Re: Status of Repair Application

Andrew Currin R.E.H.S.
Environmental Health Specialist
Harnett County Department of Public Health

IMPROVEMENT PERMIT 22886

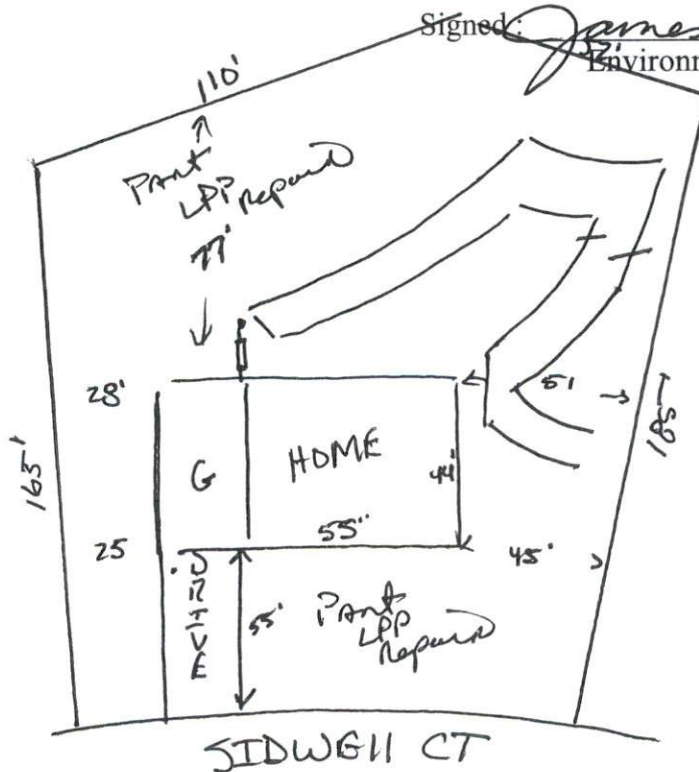
5. Driveway not shown on site plan (Revision Required)
